CITY OF
Albuquerque
Public Works Department

February 5, 1997

**RE: SAN IGNACIO SUBDIVISION (J14-D115). ENGINEER'S CERTIFICATION FOR
RELEASE OF FINANCIAL GUARANTEES. ENGINEER'S CERTIFICATION DATED
1-30-97.**

SITE, GRADING AND DRAINAGE

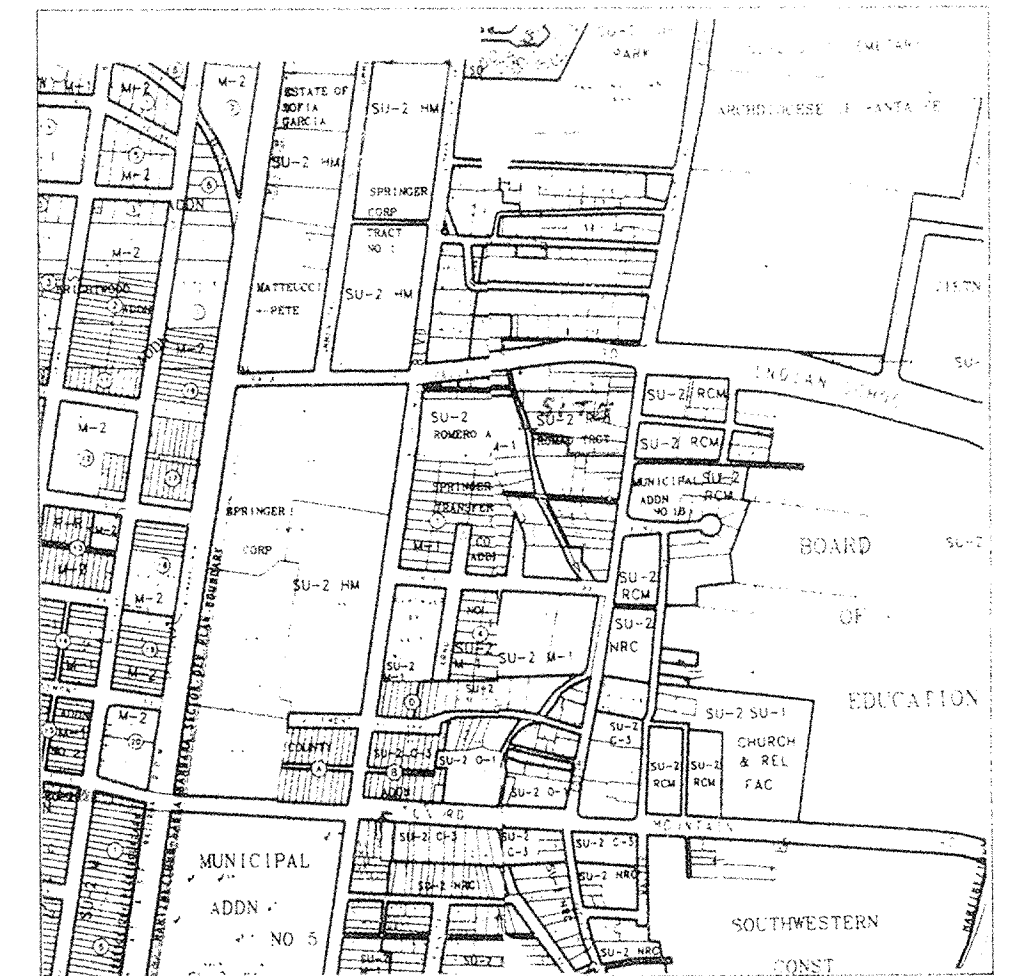
1. While I feel confident that you were approved for Final Plat, there is nothing in the Hydrology file to indicate this approval. Please submit a copy of the approved (signed-off) plat. Do you have an approval letter for the grading plan?
2. Other than the drop inlet, I can't tell where you took as-built elevations. Please provide as-built elevations in accordance with the DPM for the finish pad, top of walls, property corners, flow lines, high points, etc.
3. Provide this office with a copy of the as-builts for the entire storm drain to Broadway.
